**From:** Kathryn Welch  
**Sent:** 30 September 2025 14:08  
**To:** Gabriella Chan [REDACTED]  
**Cc:** REMICT Info [REDACTED]  
**Subject:** RE: LU/141/25/PL 57 River Road Littlehampton

I just wanted to confirm the site address provided on the application form, which has been transferred to the application documents, states the site is at **57 River Road**. However, my mapping data, and the on-street numbering of the neighbouring property, indicate the site is actually **47 River Road**.

North Arrow	
Project	
47 River Rd, Littlehampton BN17 5BF	
Drawing Title	Drawing Number
PROPOSED SWEPT PATH ANALYSIS - CAR PARK	A_600
Scale	Date
1:250 @ A3	26/04/2024
Status	Revision
PLANNING	P_01

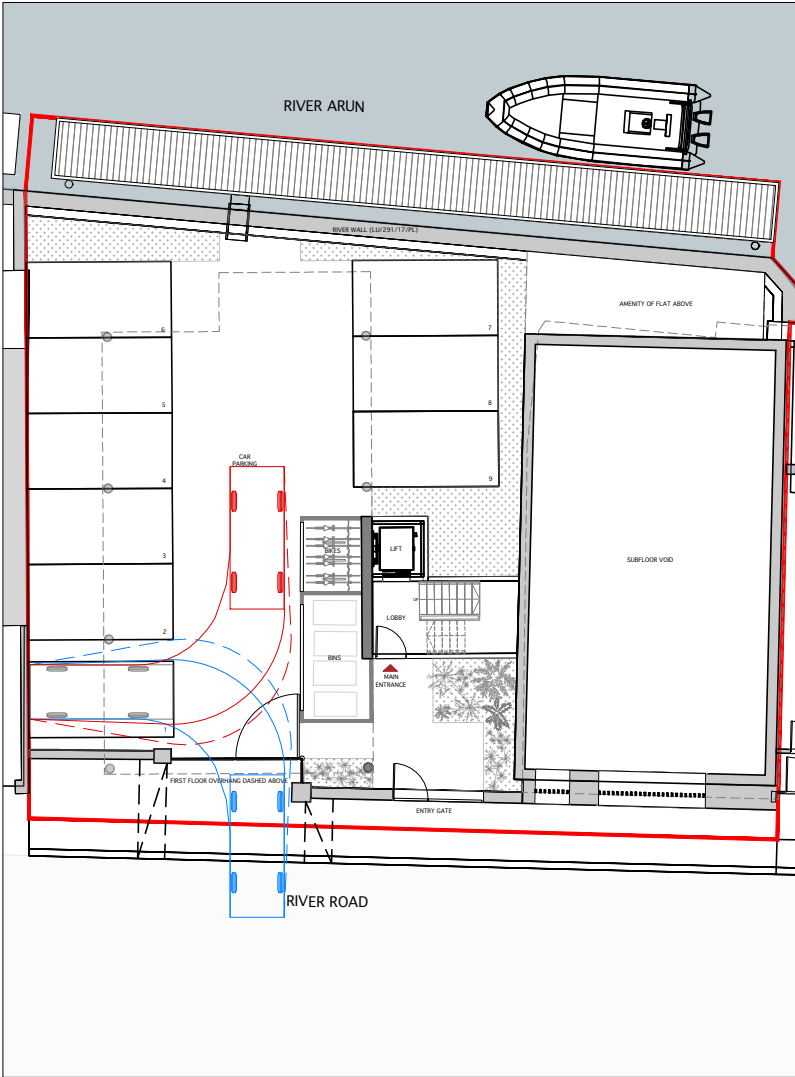
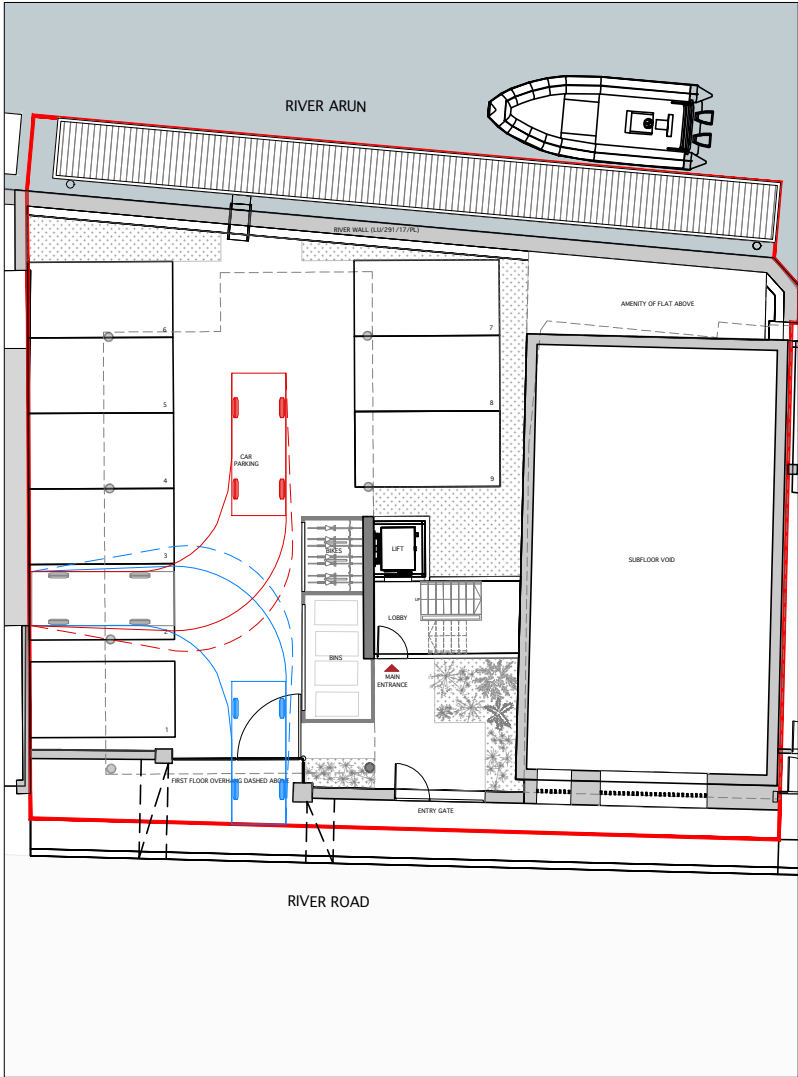
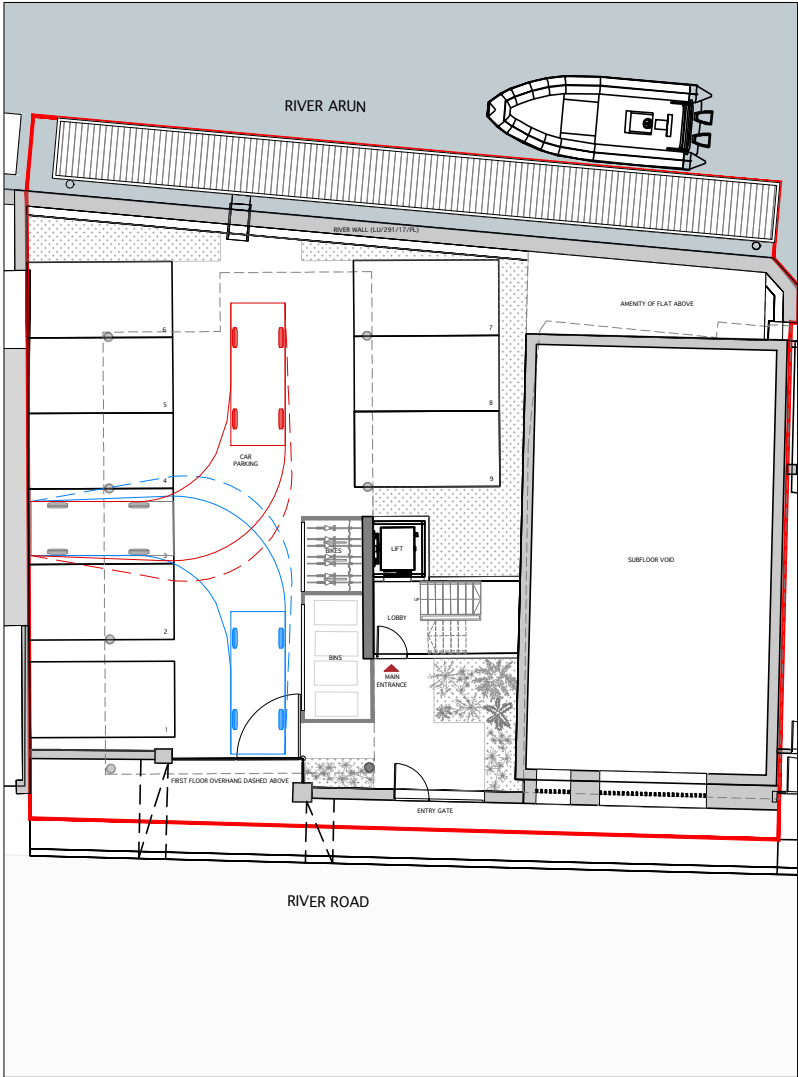
Further to the below, please see the attached Highways comments. They may not have seen the plan showing the tracking for parking space 1 but regardless they also ask for details ref parking spaces 2 and 3. Can you provide an amended plan to me, and I will then re-consult them.

*I write to ask whether you can arrange for some tracking drawings to demonstrate how cars will enter and exit parking space 1 (by the entrance) in a forward gear.*

In response to their request, please see attached drawing A\_600 Swept Path Analysis. This plan demonstrates tracking movements for a standard vehicle entering and exiting Parking Spaces 1, 2 and 3 in forward gear. The swept-path analysis confirms that access and turning can be achieved within the site for these bays.

**RESPONSE:** Please see the attached revised drawing A\_100, which includes tracking for Parking Space 1 as requested. The swept-path analysis illustrates a standard vehicle (refer to the notes column for details) entering and exiting Parking Space 1 in forward motion. We trust that these diagrams will satisfy the requirement.
